Y/61/19/PL

The application site as submitted includes a Listed Building. This building is known as Wayside Cottage and is listed Grade II. These comments relate to revised plans submitted in October 2019.

The application is for variation of condition imposed on planning permission Y/53/16/PL relating to condition no.4 and requests an amendment to the site layout.

Site Plan (Proposed) 1:200

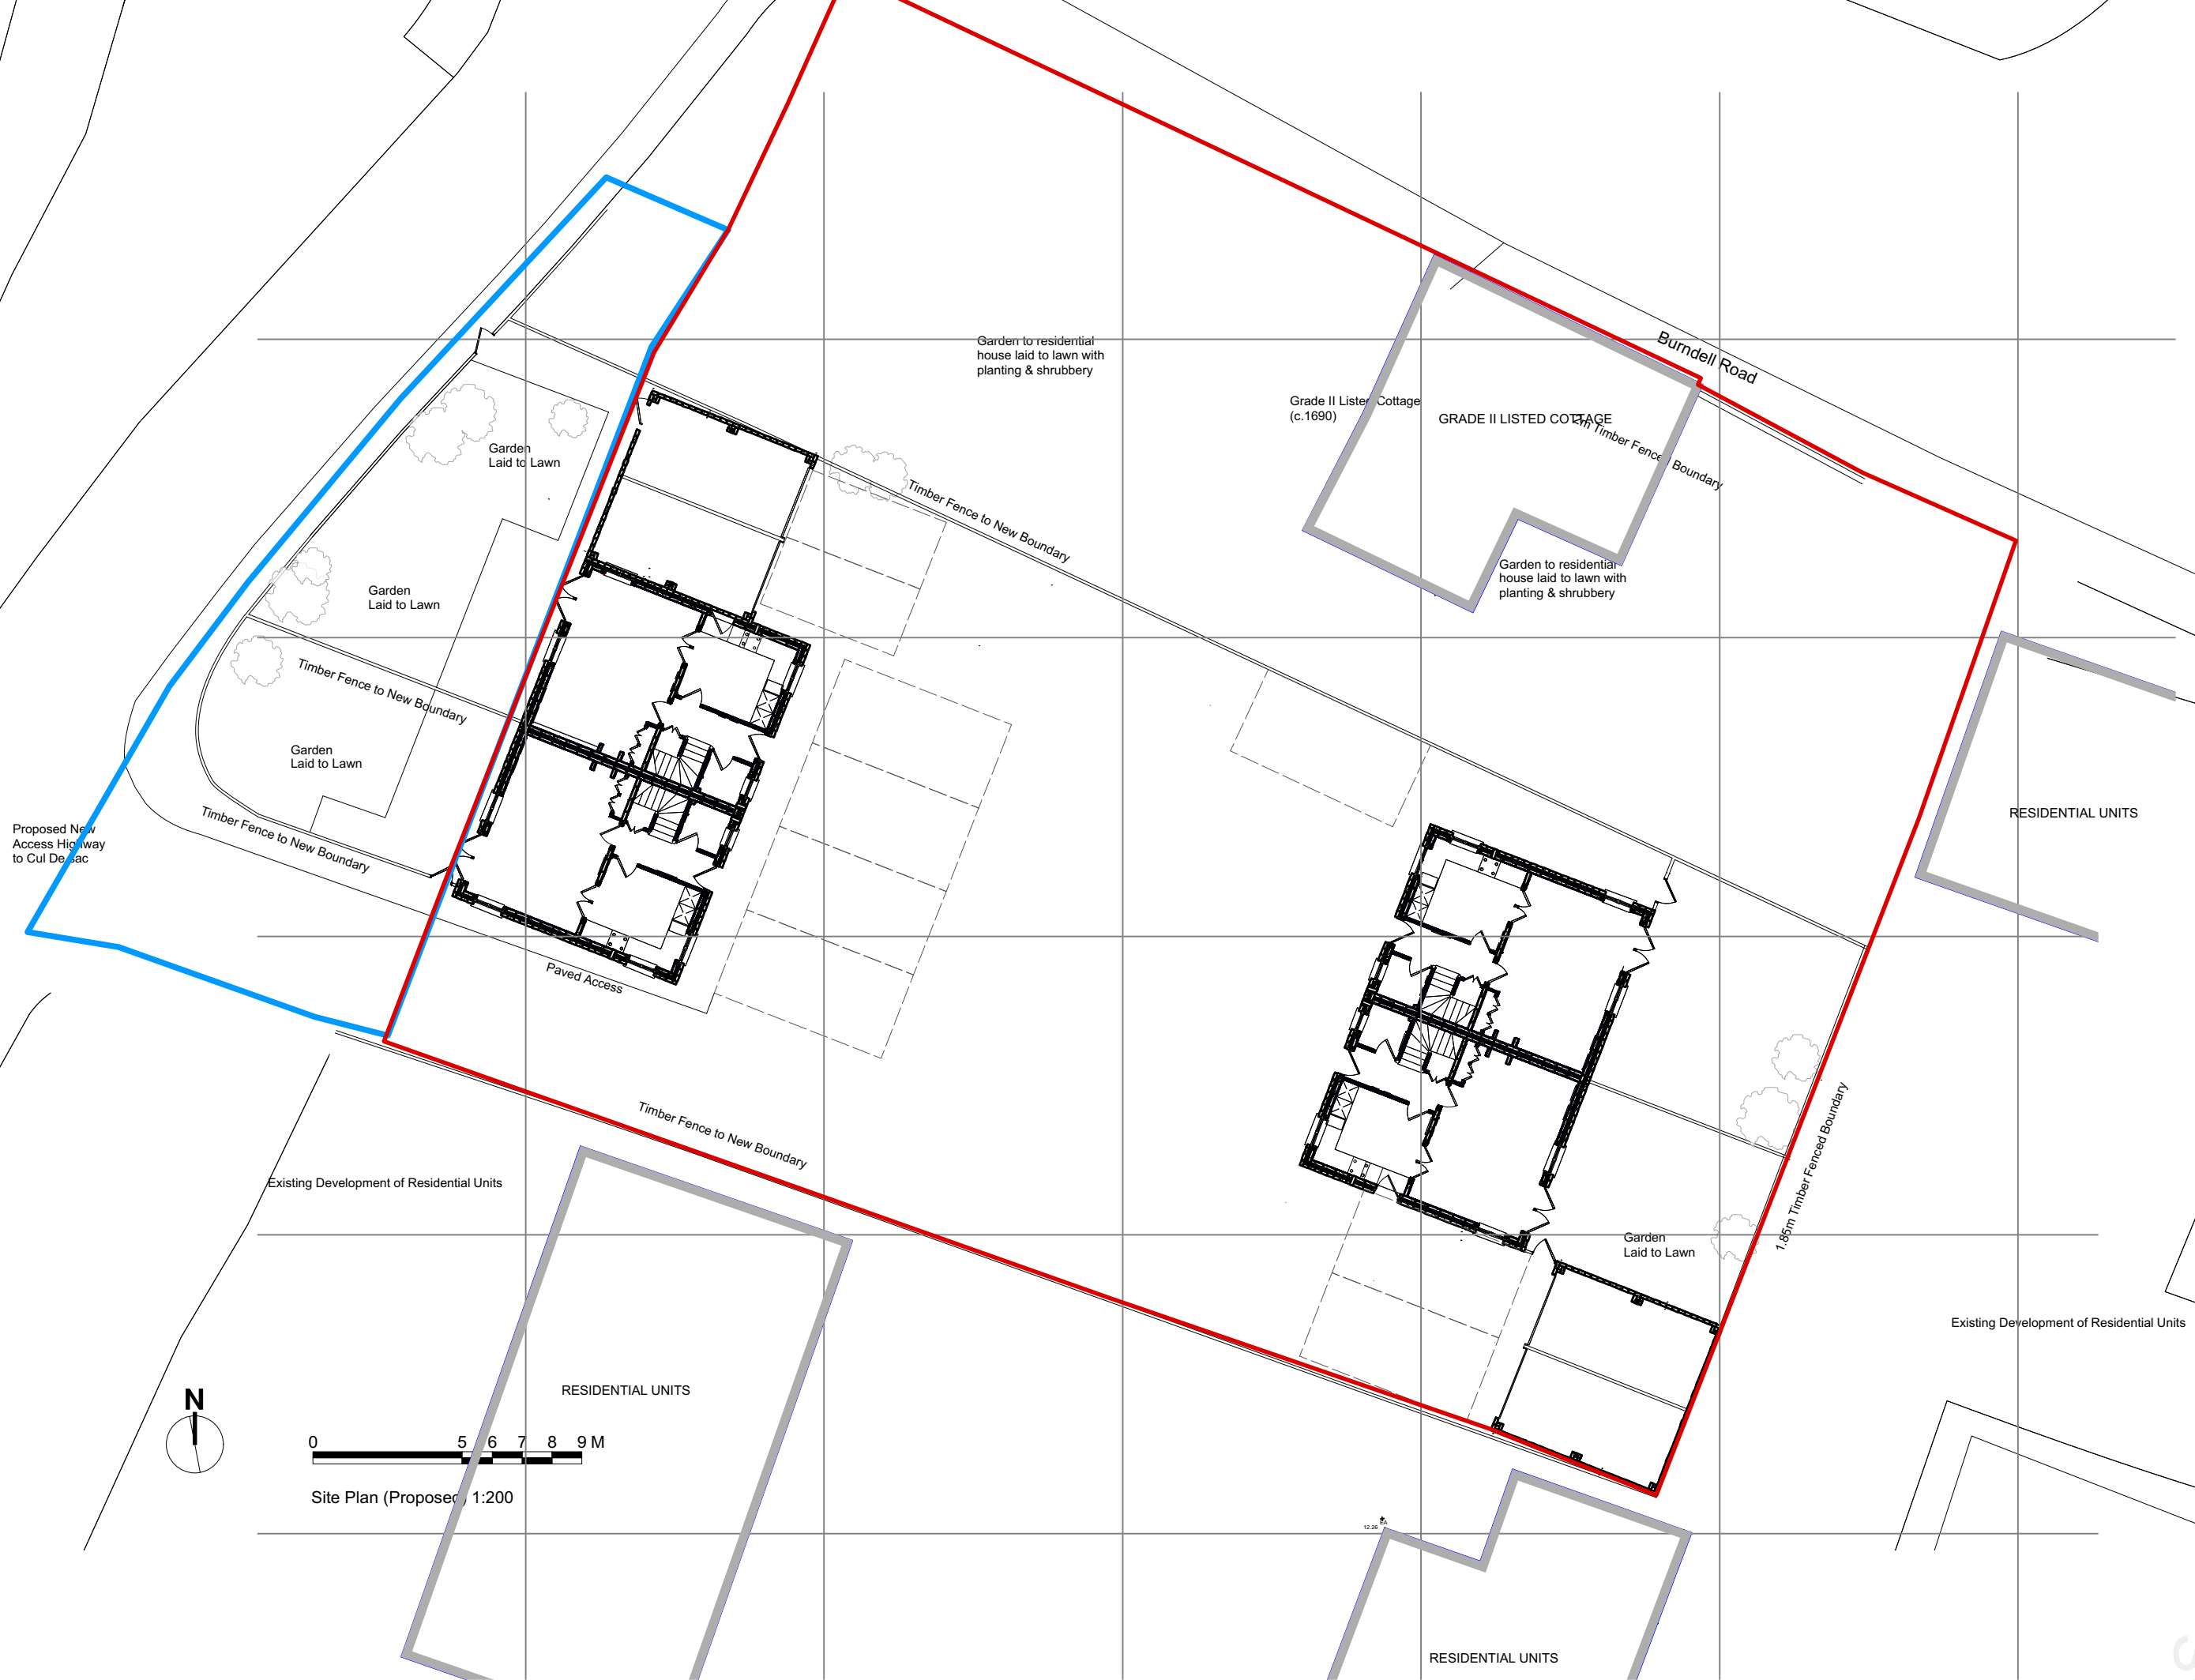
Whilst it would appear that the intention of the approved layout was to ensure that the impact on the setting of the cottage would be minimised, it is considered that the plans do actually encroach close to the listed building. As a consequence, they are considered to have a negative impact upon the setting of the listed building.

The revised plans propose that two of the boundaries of the private amenity space for units 1 and 2 are provided in the form of hedging. Such an approach is acceptable as it helps to maintain a more rural character in the local area. However, it is recommended that mature hedging should be used as part of the proposal so as to ensure that the impact of the proposal is reduced on completion of the development.

I also note that another element of landscaping between the new buildings and the listed building is to be removed as well, which is unfortunate. It is suggested that additional planting could be provided within the larger site area as a means of reducing the impact of the development on the listed building.
